Consultation response from KC, Public rights of way (PROW) - footpaths

2026/91468 Land adj. 18 Broadacres, Honley, Holmfirth, HD9 6ND

Erection of 1 dwelling and associated works

Date Responded: 21/08/2026

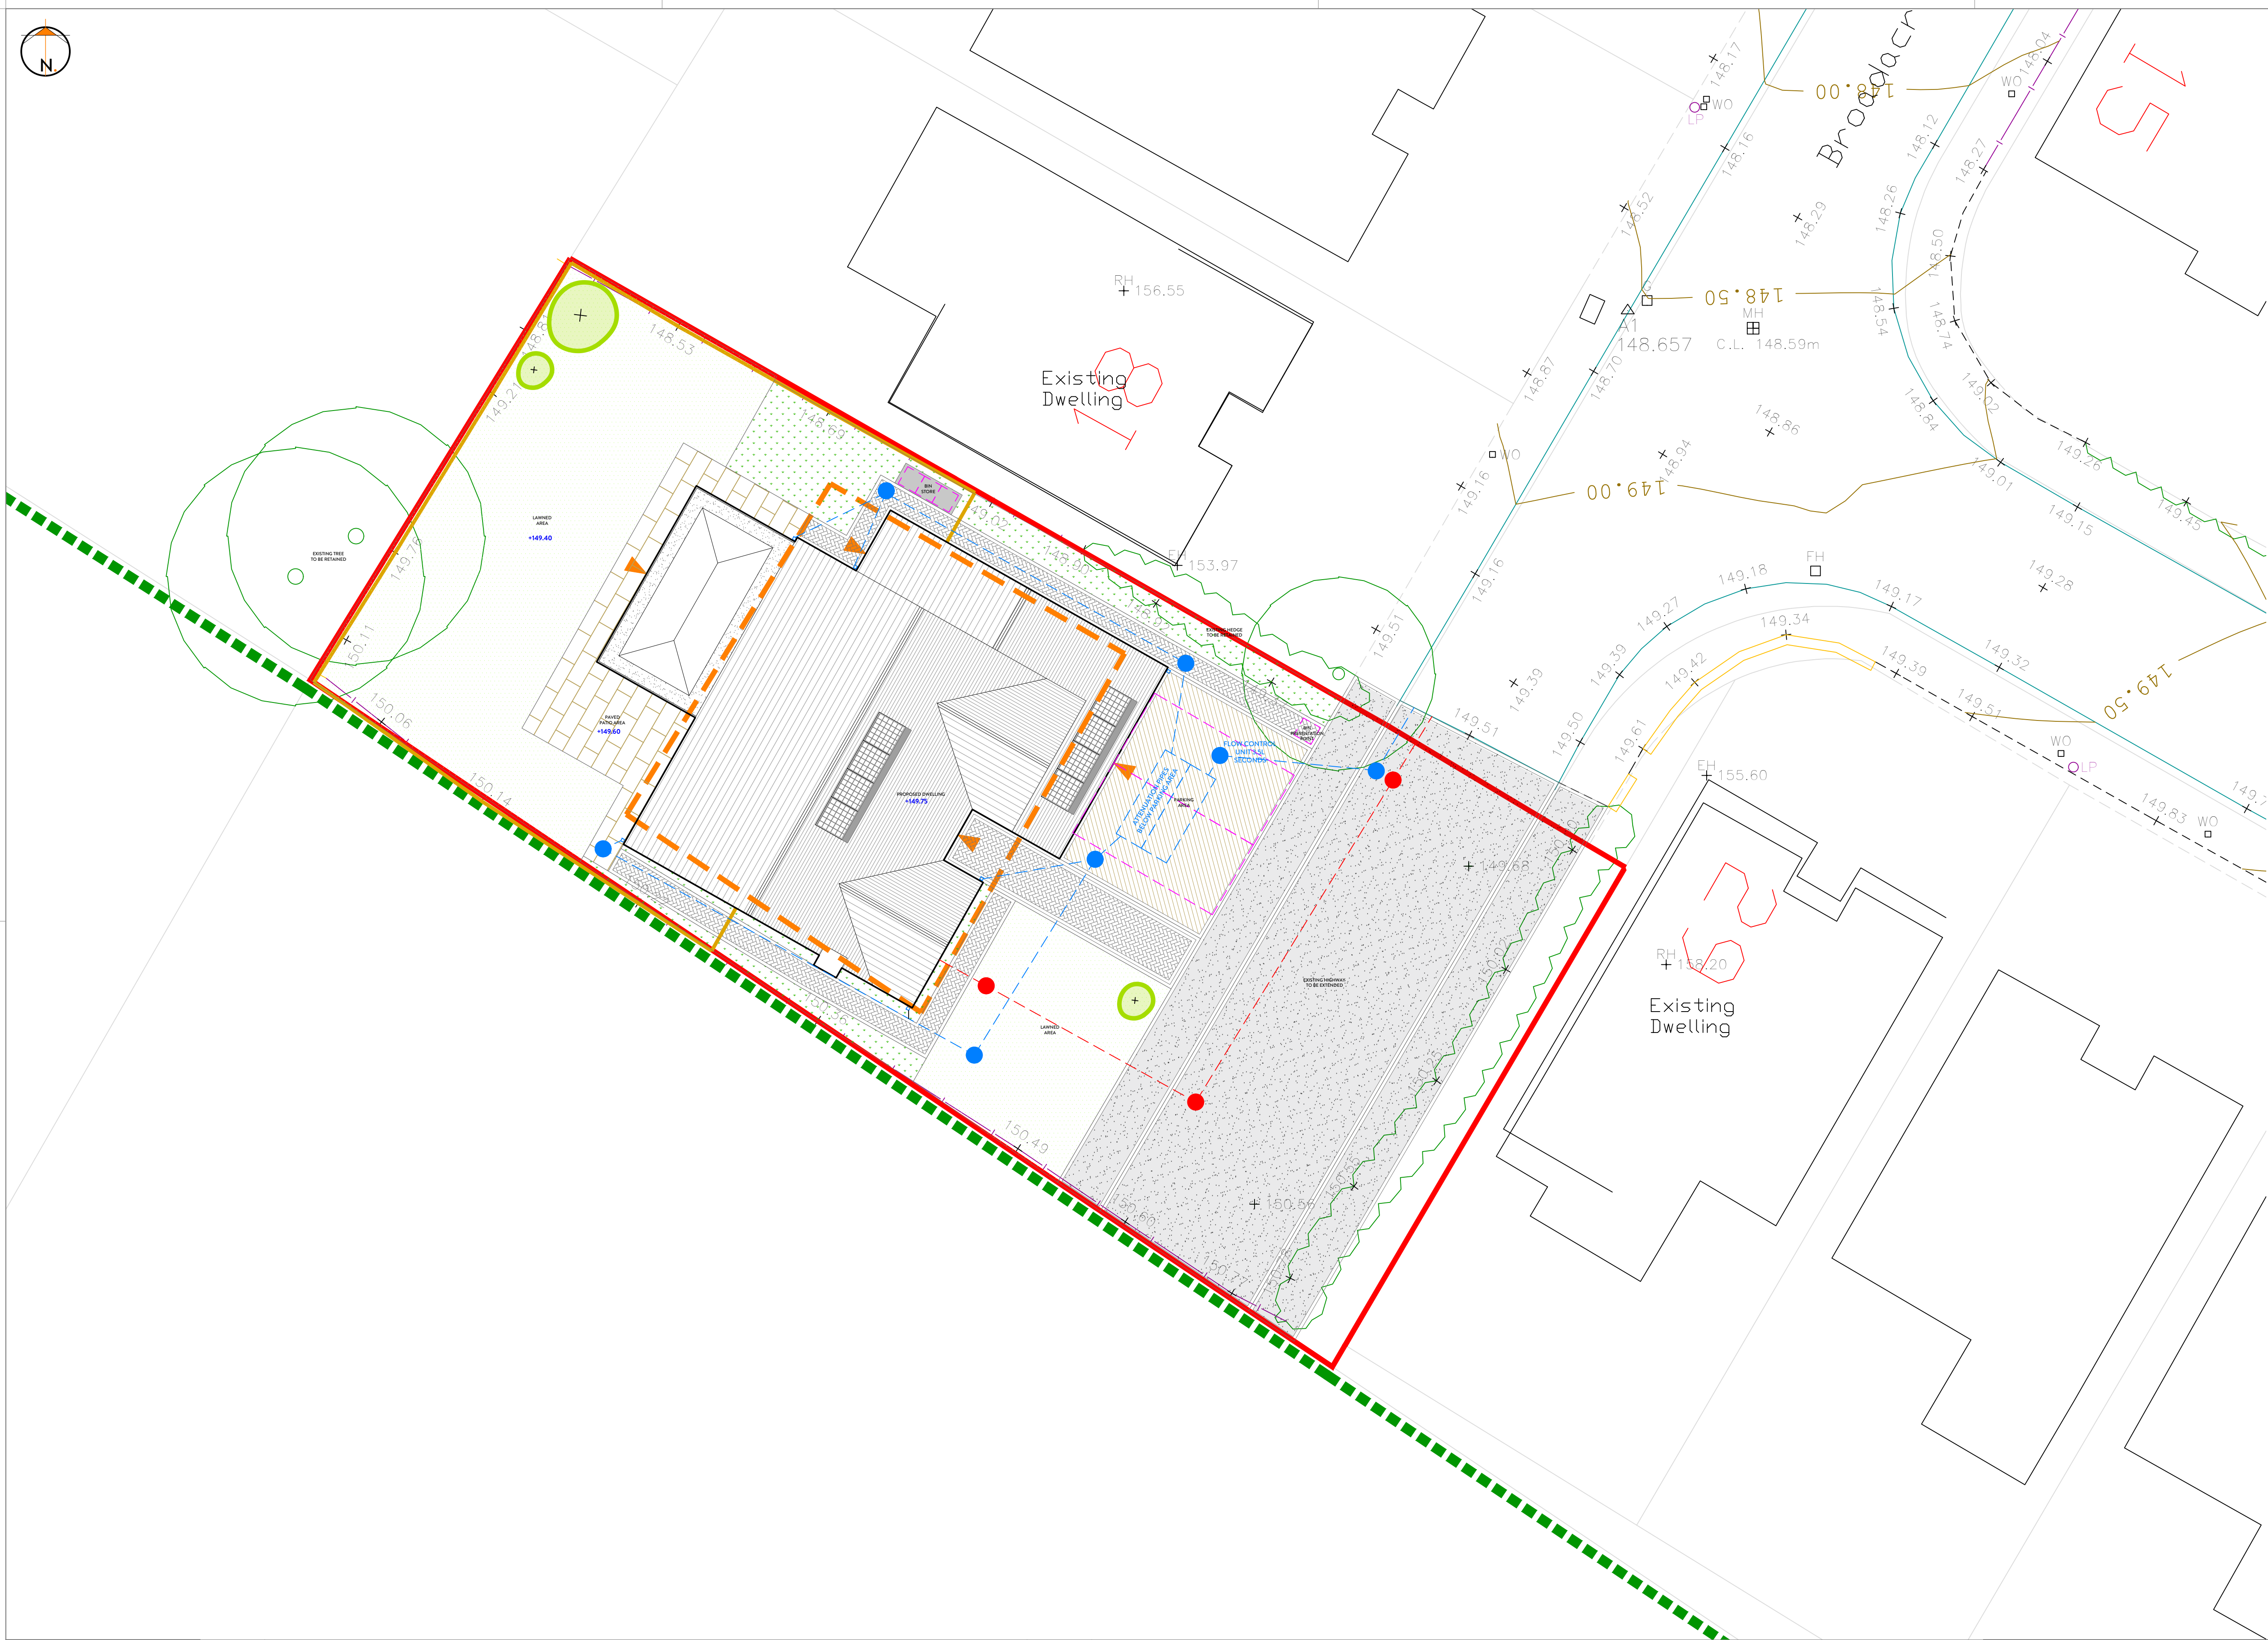
With reference to the proposed site plan (20)002, the route claimed appears to pass through the red line boundary of the development site, including the proposed dwelling, parking, paving and lawns, etc. Should the development receive planning permission, and it is found that a public right of way subsists through this site, it would be necessary for any public right of way within this site to be stopped up or diverted. Should the route be diverted and enclosed by fences or walls, we advise that the minimum width required would be 2 metres.
